High Plains, SF-18-024

Please accept the following comments from El Paso County Public Health (EPCPH) regarding the 39.4 acre, 7 residential lot development project referenced above:

High Plains, SP-18-003

FINAL PLAT
HIGH PLAINS FILING NO. 1
A PORTION OF THE SOUTHWEST QUARTER OF THE SOUTHEAST QUARTER OF SECTION 19, TOWNSHIP 11 SOUTH, RANGE 65 WEST OF THE 6TH P.M. COUNTY OF EL PASO, STATE OF COLORADO

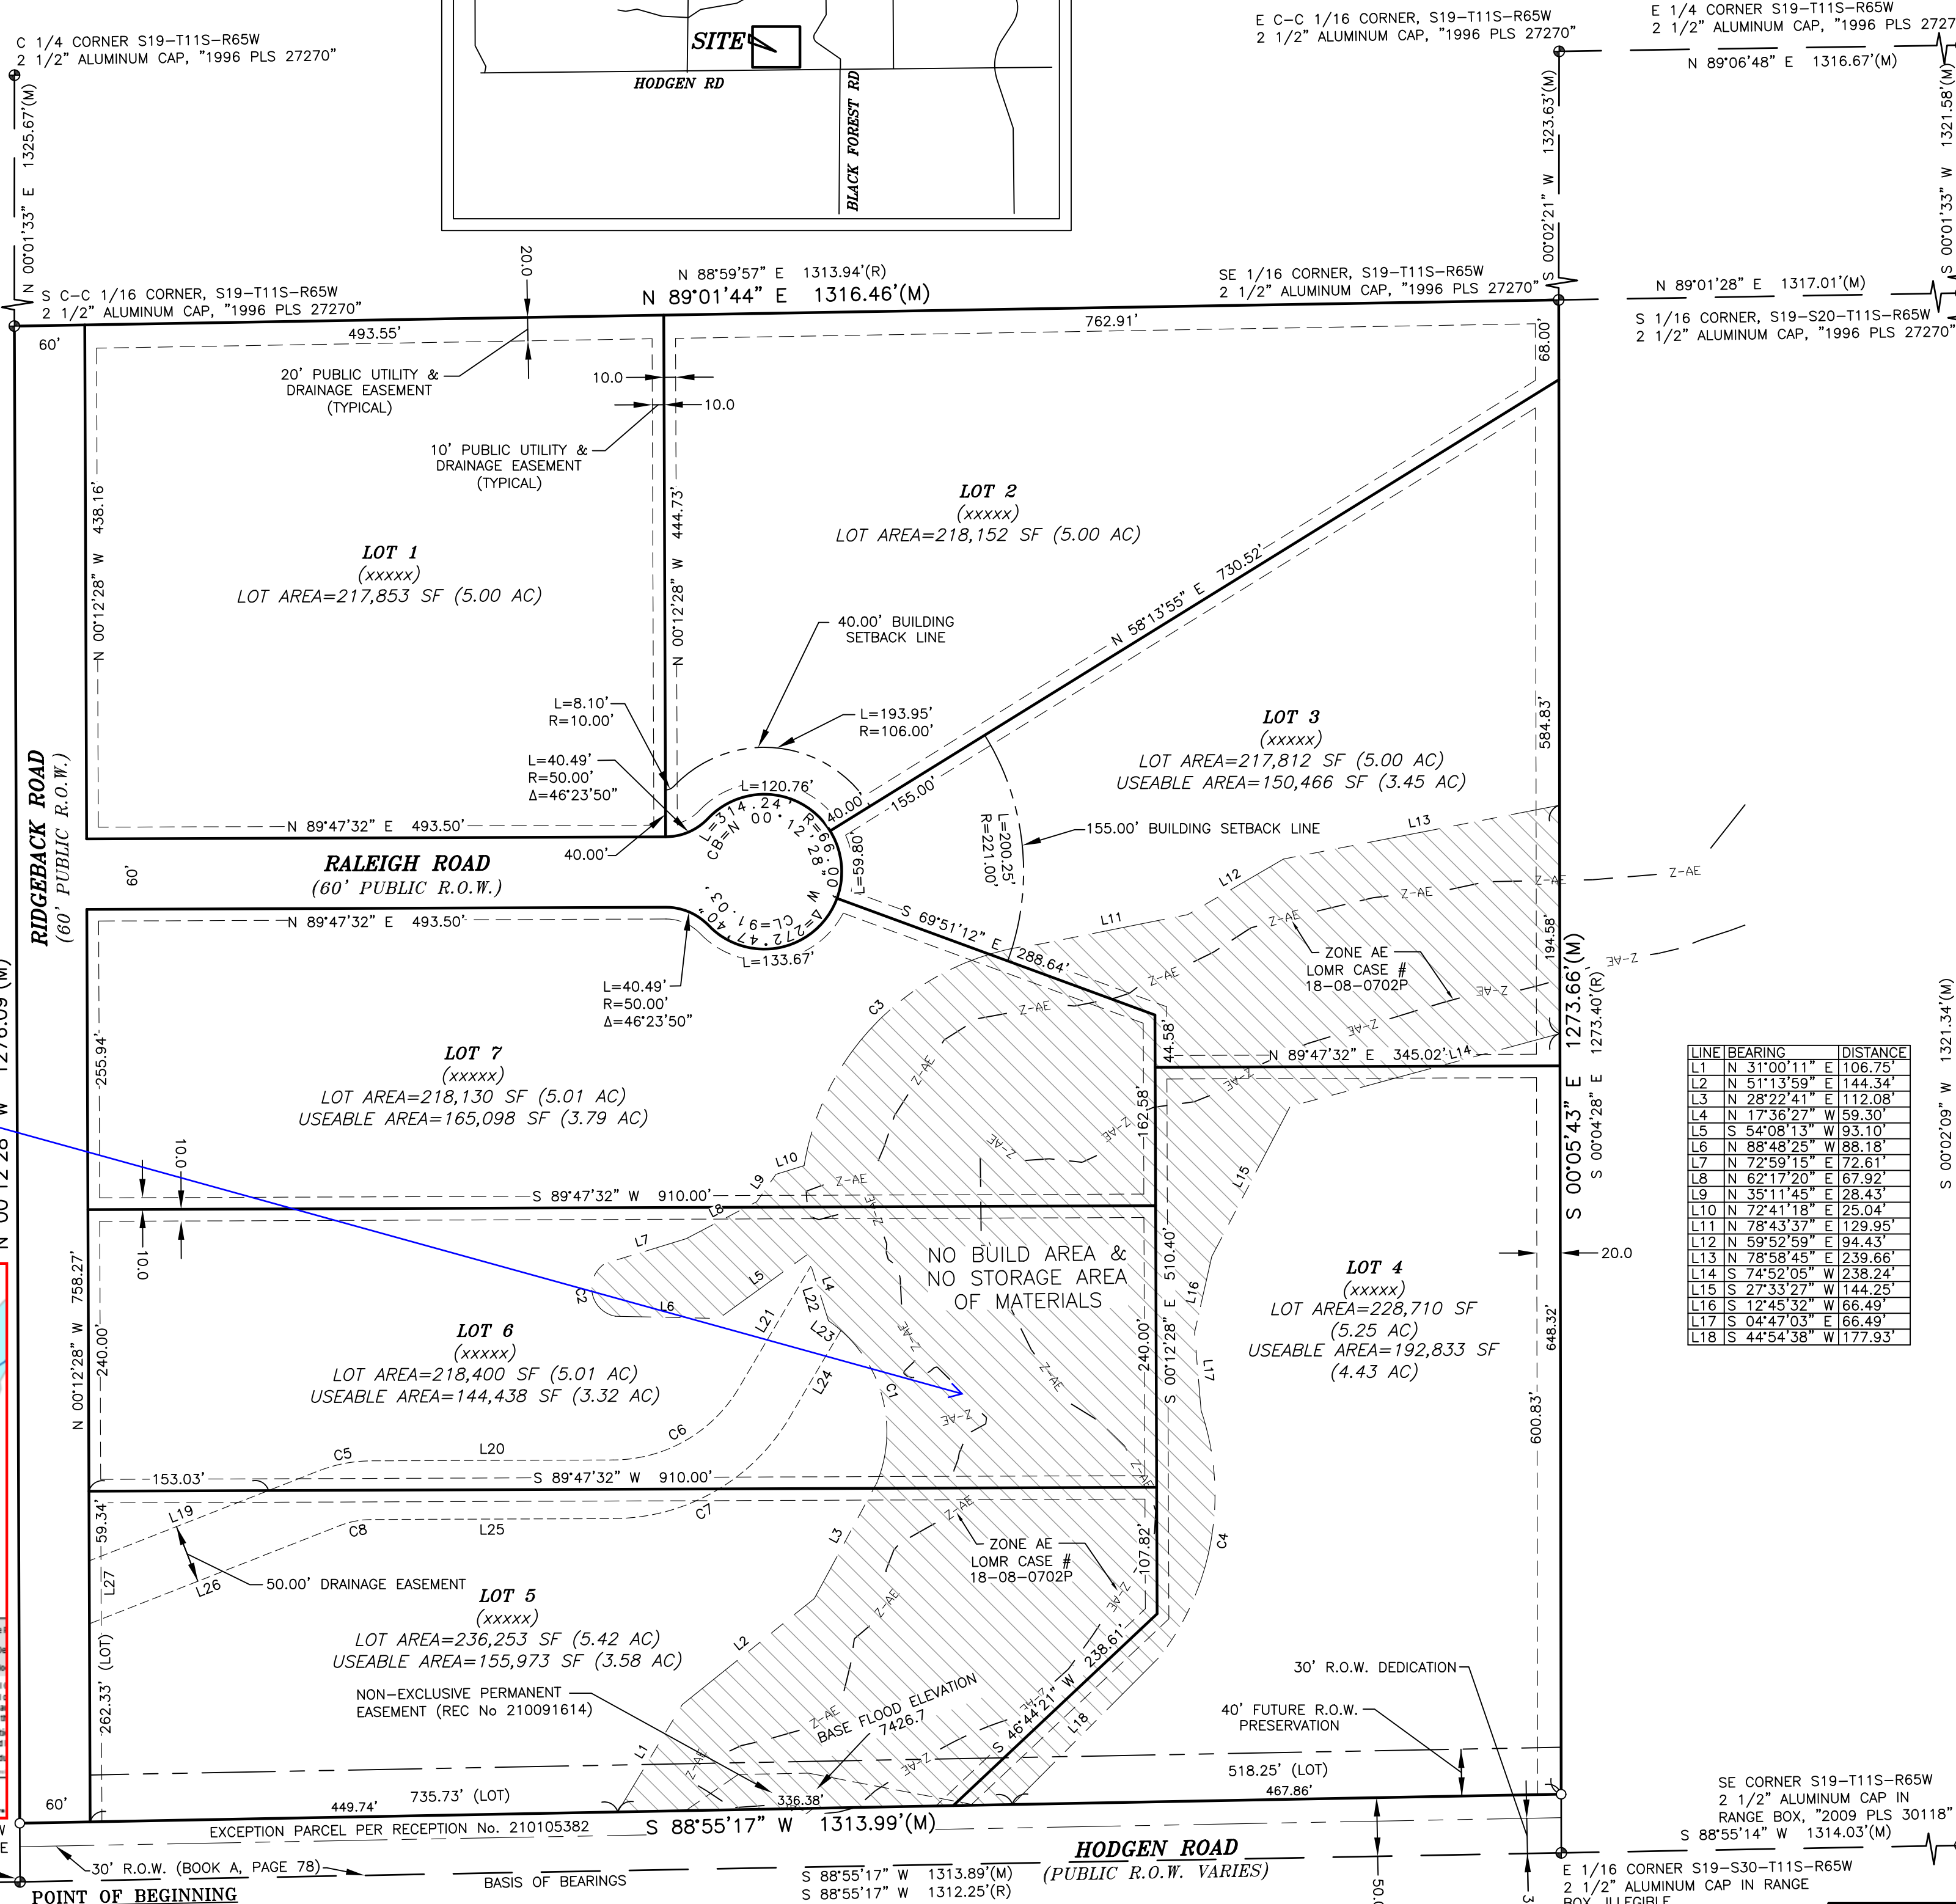
- Careful planning is required when locating a private well and onsite wastewater treatment system (OWTS) on lots 3 and 6 due to identified areas of potential seasonal shallow groundwater identified in the Entech Engineering, Inc., Soil, Geology, Geologic Hazard, and Wastewater Study Report.
